Bent Grass East Commercial  
Filing No. 3  
Updated Traffic Impact Analysis  
PCD File No. SP2010  
(LSC #204660)  
May 17, 2021

# LSC Responses to EPC TIS Redline Comments

**TYPICAL PRIVATE ROAD CROSS SECTION**  
 SCALE: 1" = 10'  
 BENT GRASS MARKET VIEW  
 (PRIVATE ROADWAY)

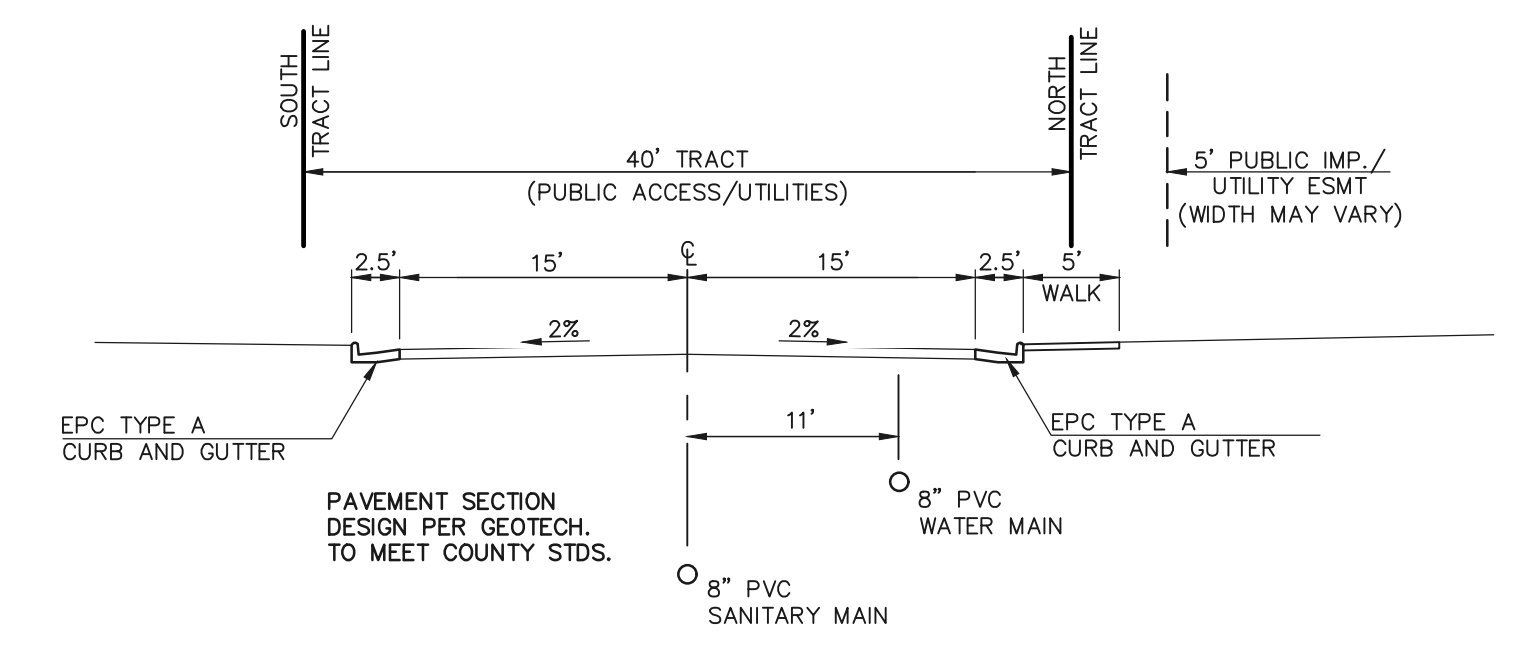
A 24 ft. cross section is not sufficient for the traffic volume/impacts of this development. Based on the proposed uses, turn lanes may be required along this private roadway and a 24ft section would not provide the required width to add any future turn lanes. These comments have also been provided in the submitted deviation request for this private roadway. This street is intended to be used only to serve the adjacent lots and not through traffic. Each lot will be required to provide sufficient on-site parking as on-street parking will not be allowed. With no on-street parking, two-way traffic will be maintained.

Comments have been provided in the turn movement exhibit as the design vehicle encroaches into the opposing lane at the radii proposed. A 24 ft. cross section is not sufficient for the traffic volume/impacts of this development. Based on the proposed uses, turn lanes may be required along this private roadway and a 24ft section would not provide the required width to add any future turn lanes. These comments have also been provided in the submitted deviation request for this private roadway.

LSC Response: This comment was discussed in the meetings with Staff and the TIS report has been updated, based on the outcomes of those meetings. The private roadway is now shown as an Urban Local and the Autoturn exhibits have been revised by Classic Consulting.
